From: Lisa Jackson <[REDACTED]>
Sent: 11 April 2022 07:43
To: Simon Davis
Subject: Fwd: Planning Consultation on: Y/32/22/DOC
Attachments: 13591-CRH-XX-XX-CA-C-0007-P1_Proposed SW Network calcs.pdf; 13591-CRH-XX-XX-DR-C-5050-P7_Proposed Drainage Layout (Sheet 1).pdf; 13591-CRH-XX-XX-DR-C-5260-P1_Subcatchment Plan.pdf; suds-design-and-adoption-guide (extract).pdf; 13591-CRH-XX-XX-DR-C-5051-P6_Proposed Drainage Layout (Sheet 2).pdf

Subject: RE: Planning Consultation on: Y/32/22/DOC

Engineers Comments Regarding Surface Water Drainage

Project No.	Originator	Volume	Lvl/Loc	Type	Role	Number	Rev
13591	CRH	XX	XX	DR	C	5051	P5

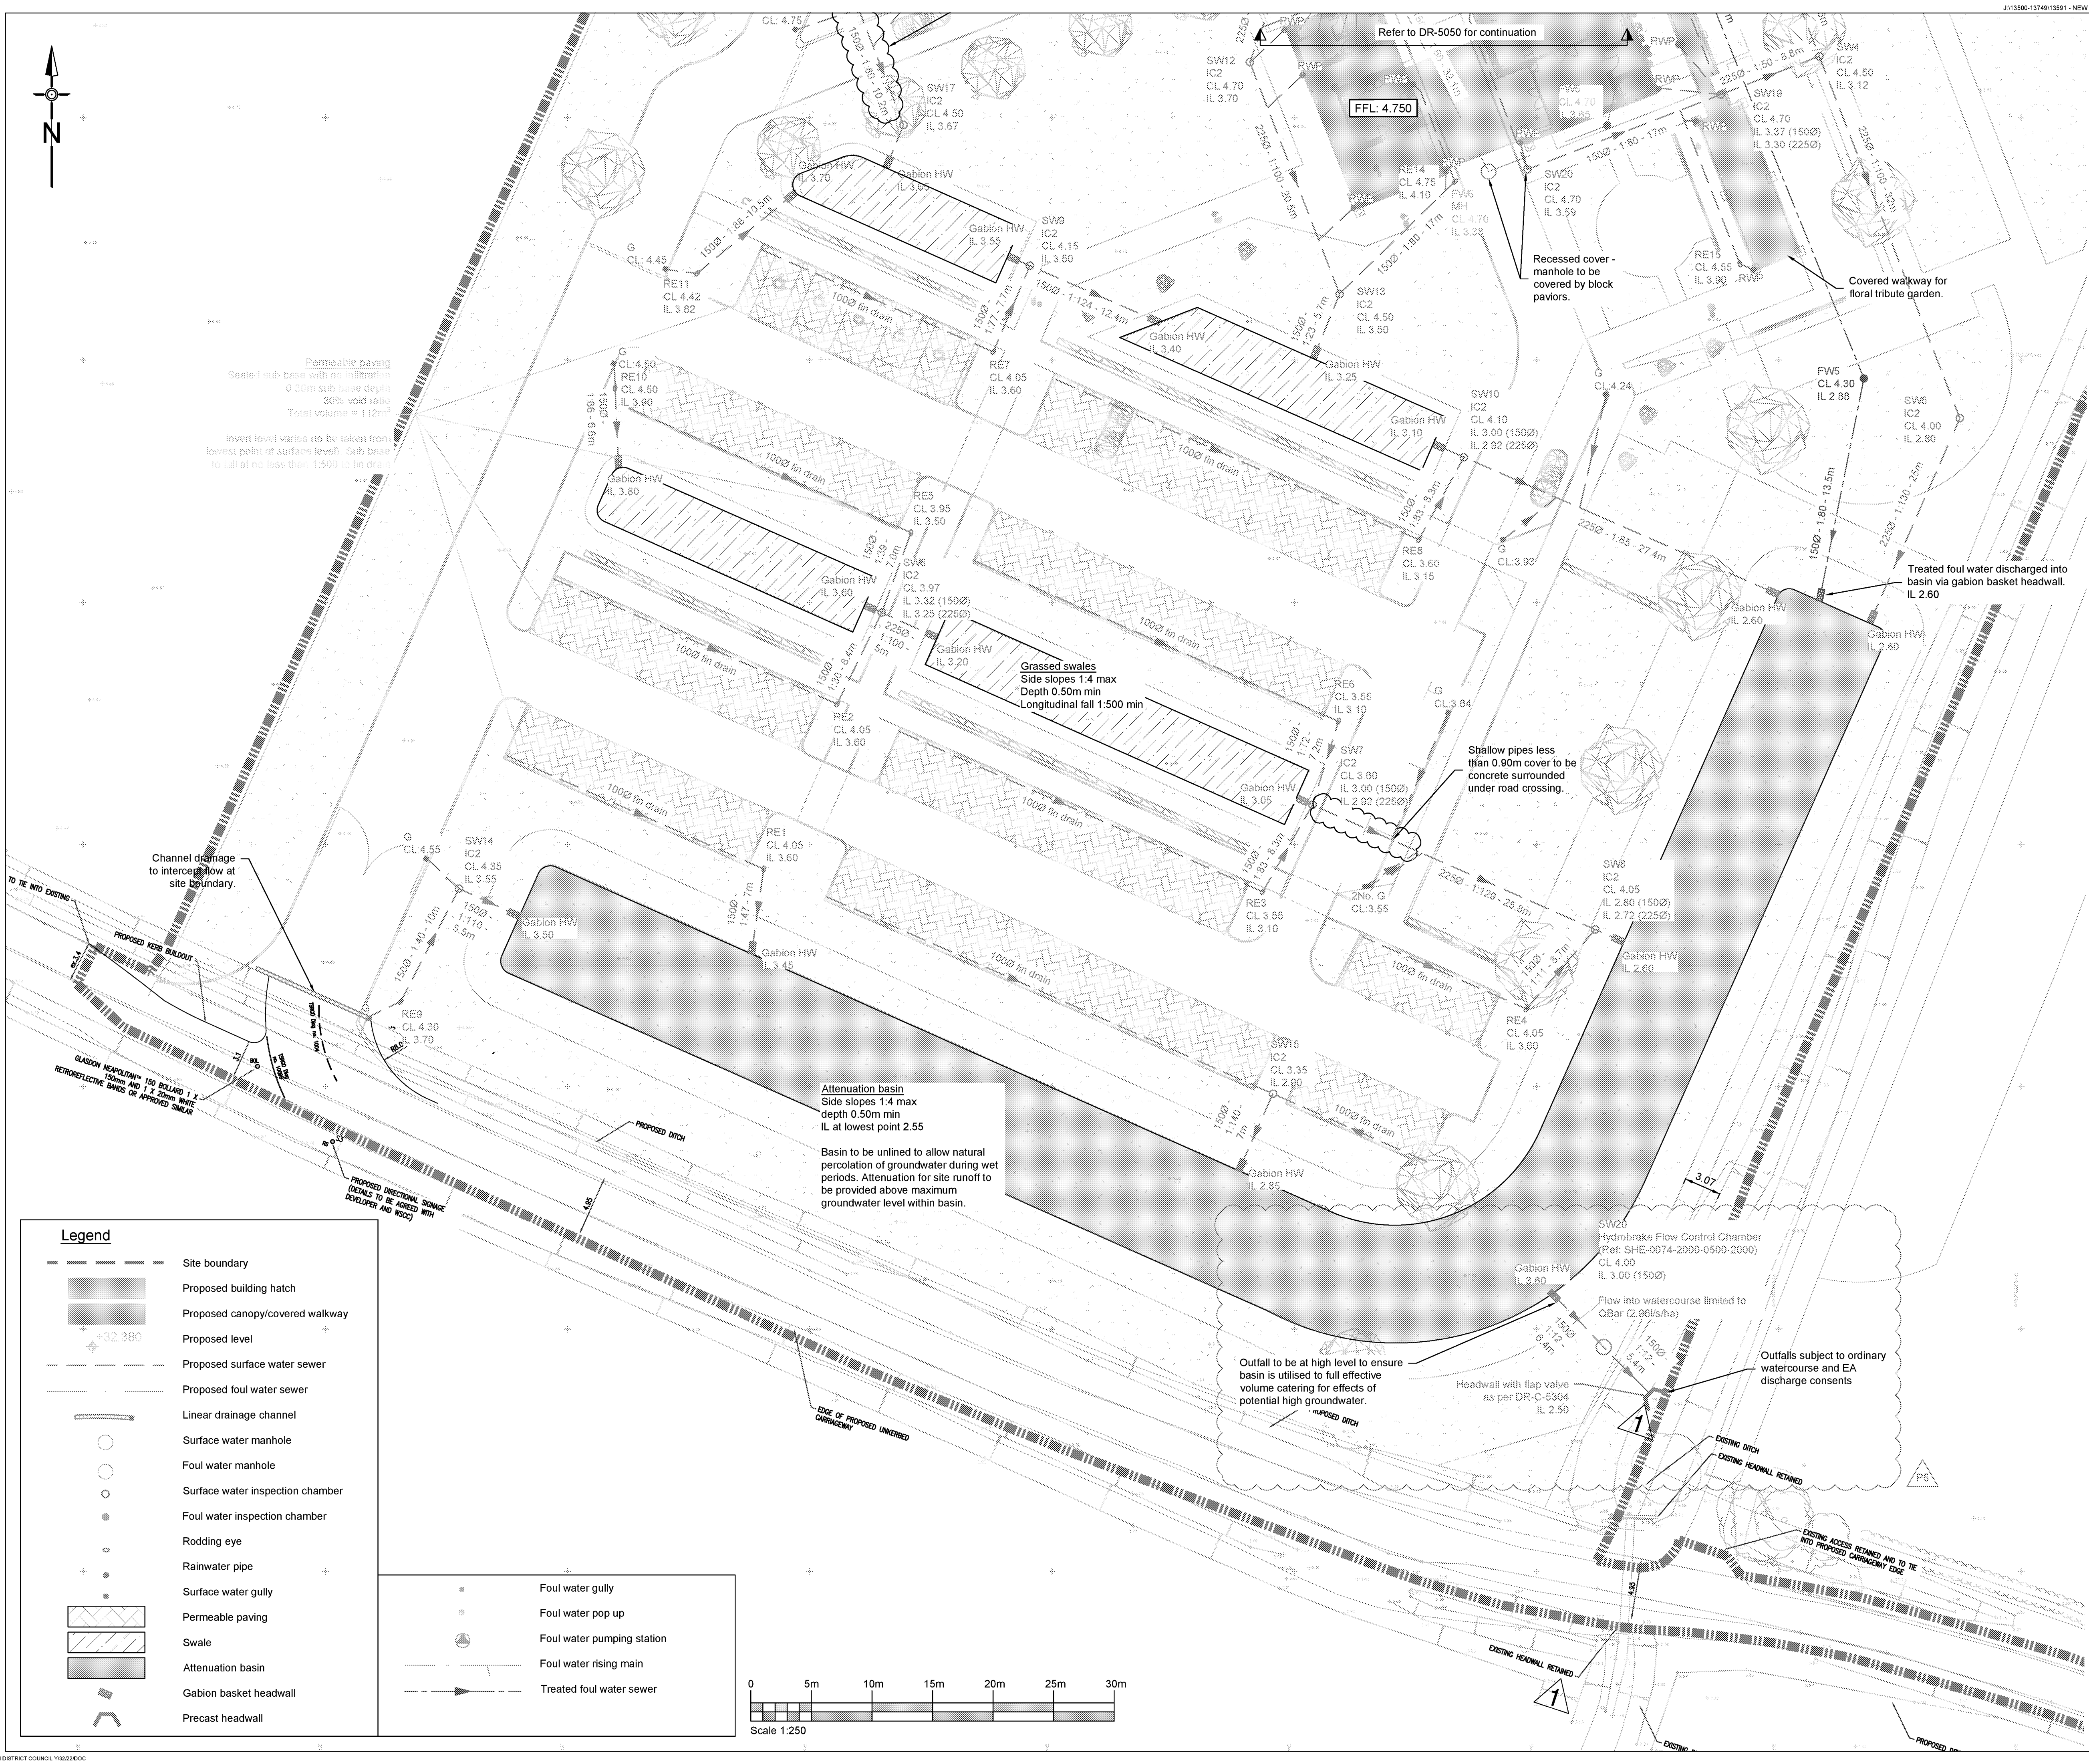
4. Please label all pipes with diameter and fall. Additional pipe labels have been added to drainage layout plans 13591-CRH-XX-XX-DR-C-5050 Revision P6 and 5051 Revision P5. Gradients for short (<5m) pipe lengths have not been shown. Pipe sizes, maximum grades and materials are to be as specified on drainage notes drawing 13591-CRH-XX-XX-DR-C-5300 Revision P1 previously provided. Okay.

5. Hydrobrake unit references should be included on layout plans. Details have been added to updated drainage layout plan 13591-CRH-XX-XX-DR-C-5051 Revision P5. Okay, but please see

Finish and formation levels of permeable paving must be detailed, thank you for providing a finished levels plan, please provide formation levels on layout plan, this is required to evidence adequacy of proposed connections from permeable paving. And to ensure correct construction. Formation levels of porous sub base of permeable paving have been added in green text to drawings DR-5050 and 5051 as requested.

7. Gullies and channel drains should be labelled with cover levels. Cover levels have been provided for proposed gullies on updated drainage layout plan 13591-CRH-XX-XX-DR-C-5050 Revision P6 and 5051 Revision P5. Channel drain cover levels will necessarily vary along the length and hence have not been provided. Exact levels will be determined by contractor to suit the finished levels as shown on levels plan 13591-CRH-XX-XX-DR-C-5200 Revision P3. *Levels should be provided on plan to ensure construction is carried out in accordance with proposals. Channel drain cover levels have been added to drawings DR-5050 and 5051 as requested.*

2. *Please supply a buffer plan to show that at least 3m is being provided between top of bank of watercourses and obstructing features, such as fences, buildings, and basins. A suitable buffer has been provided between top of basin and edge of watercourse to allow for maintenance, as shown on drawing 13591-CRH-XX-XX-DR-C-5051 Revision P5. Buffer not clearly shown, please show the buffer on a plan. A buffer has been shown on drawings DR-5050 and 5051 as requested.*

Project No.	Originator	Volume	Lvl/Loc	Type	Role	Number	Rev
13591	CRH	XX	XX	DR	C	5250	P1

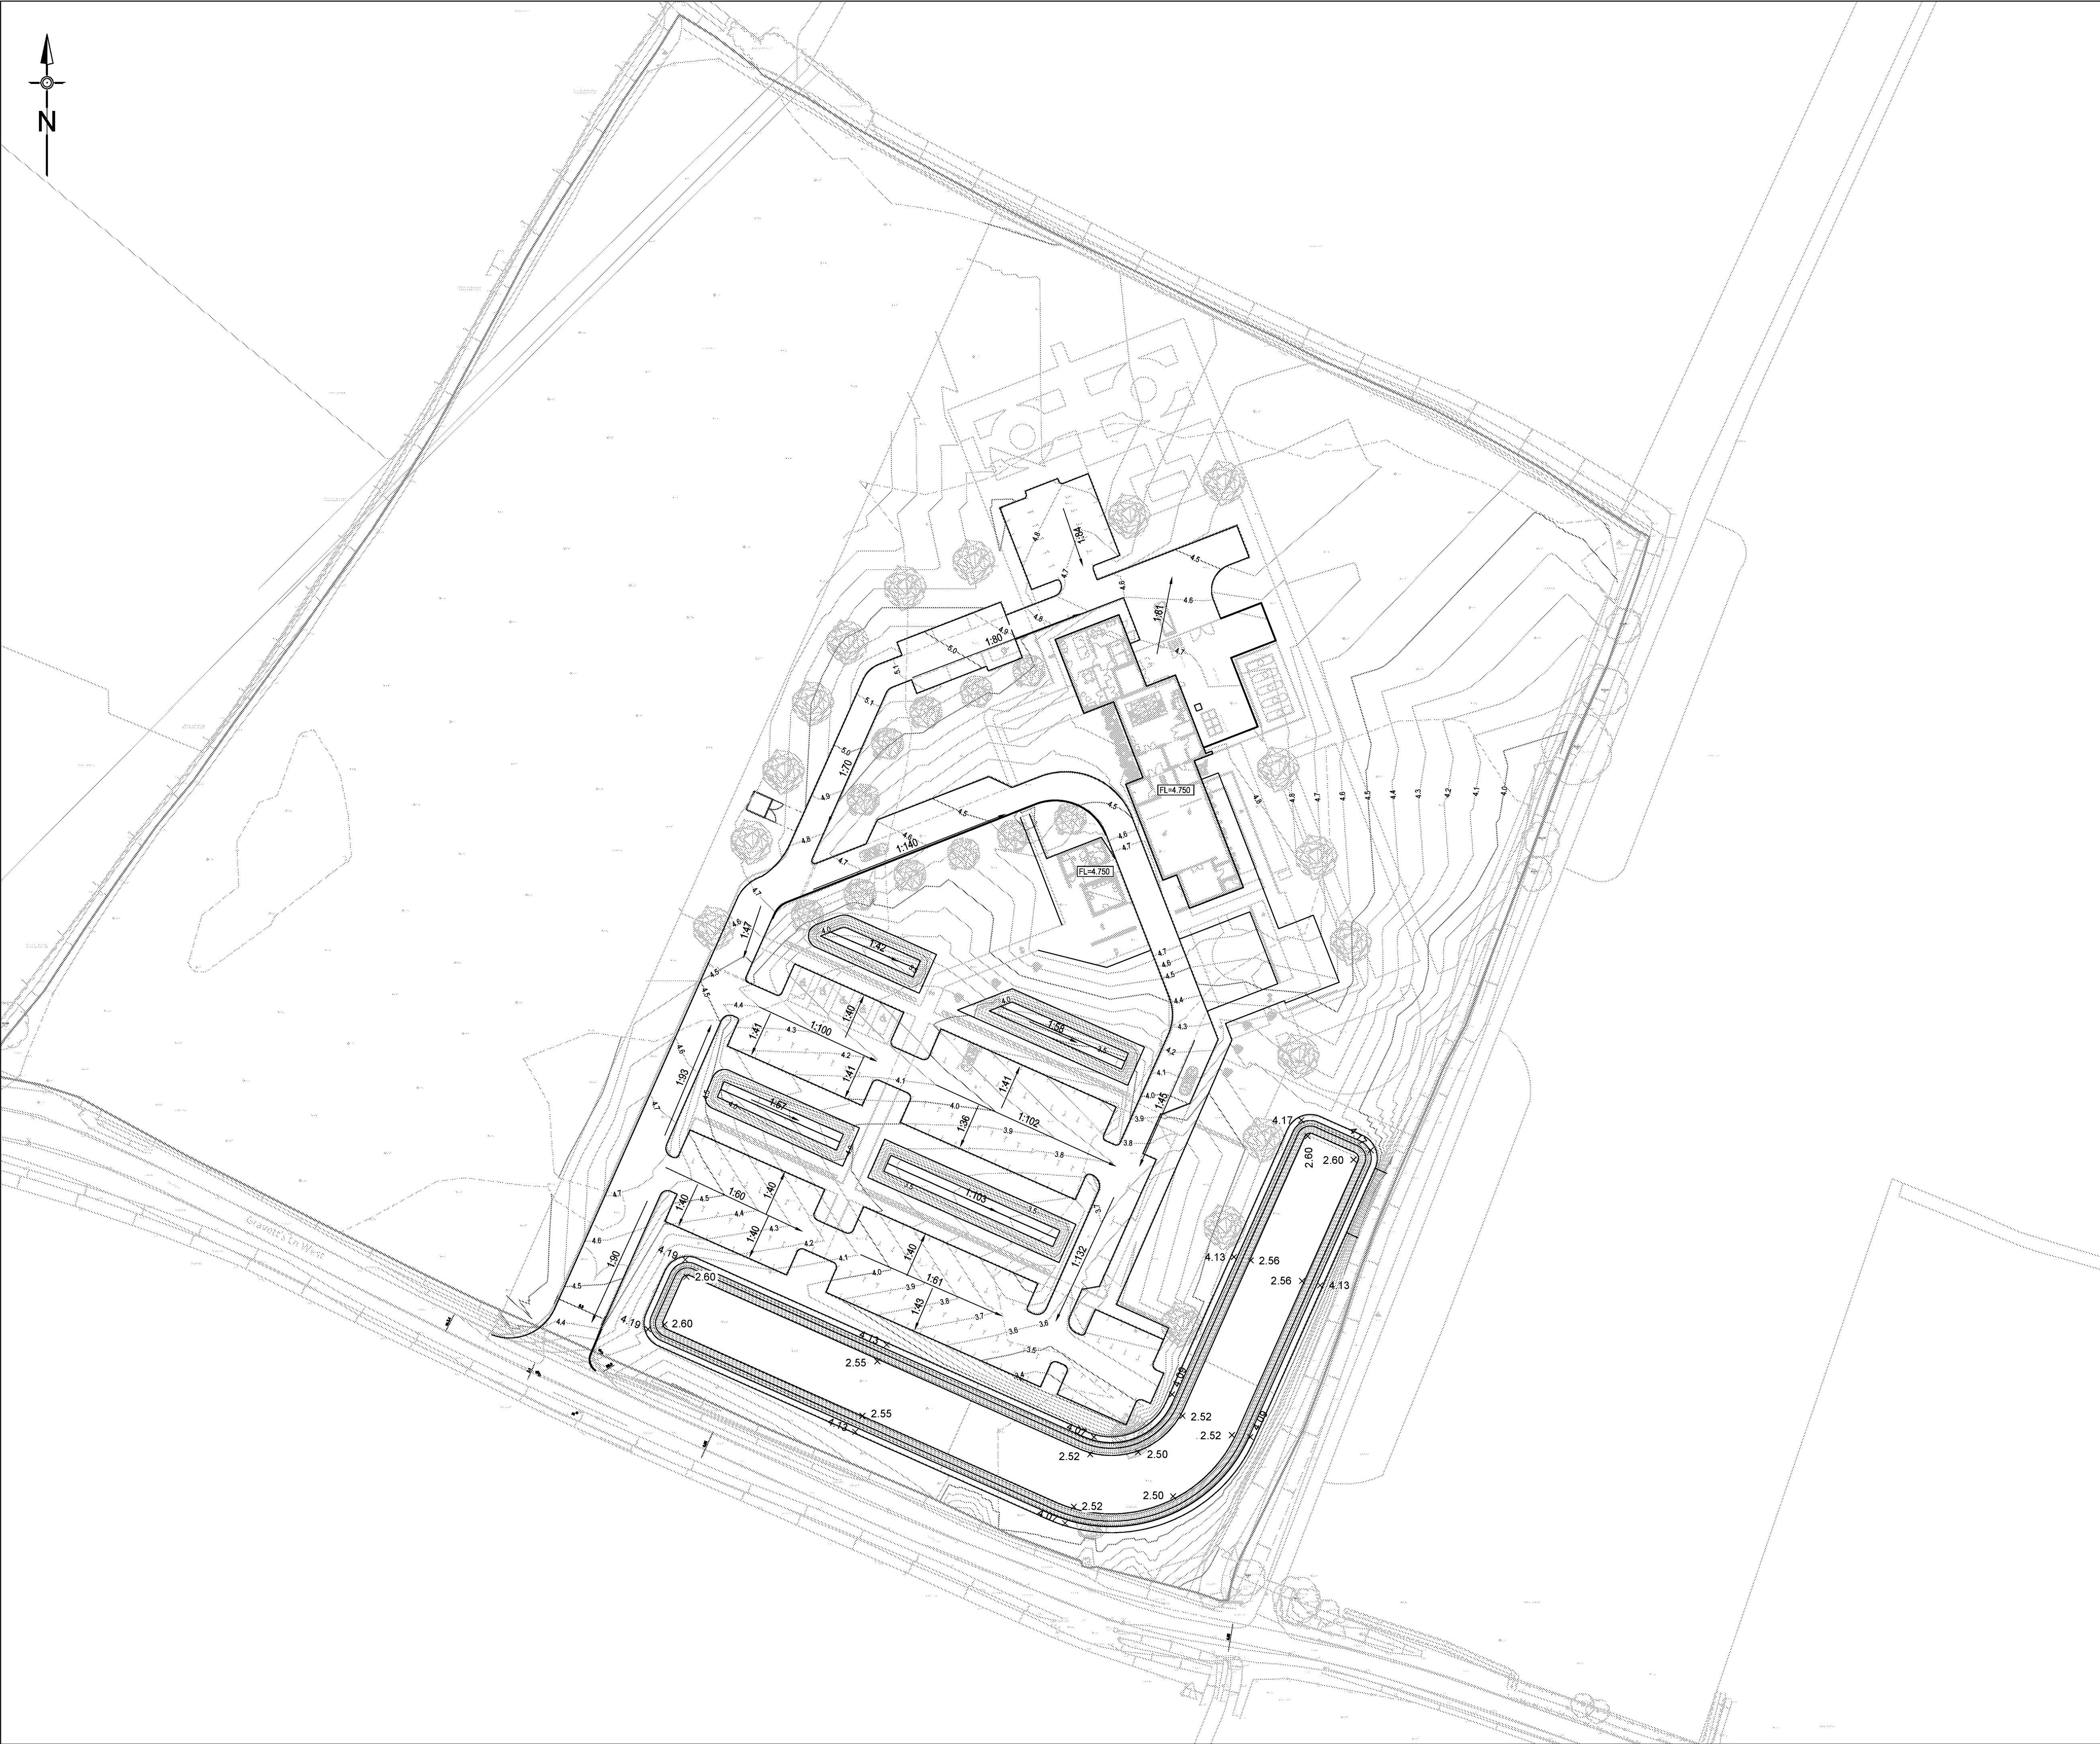
3. Please supply an impermeable area catchment plan. Please see enclosed impermeable area plan 13591-CRH-XX-XX-DR-C-5250 Revision P1. Okay. We have also included the additional detailed sub-catchment plan 13591-CRH-XX-XX-DR-C-5260-P1 to accompany the drainage calculations and provide absolute clarity as to which areas contribute to the model.
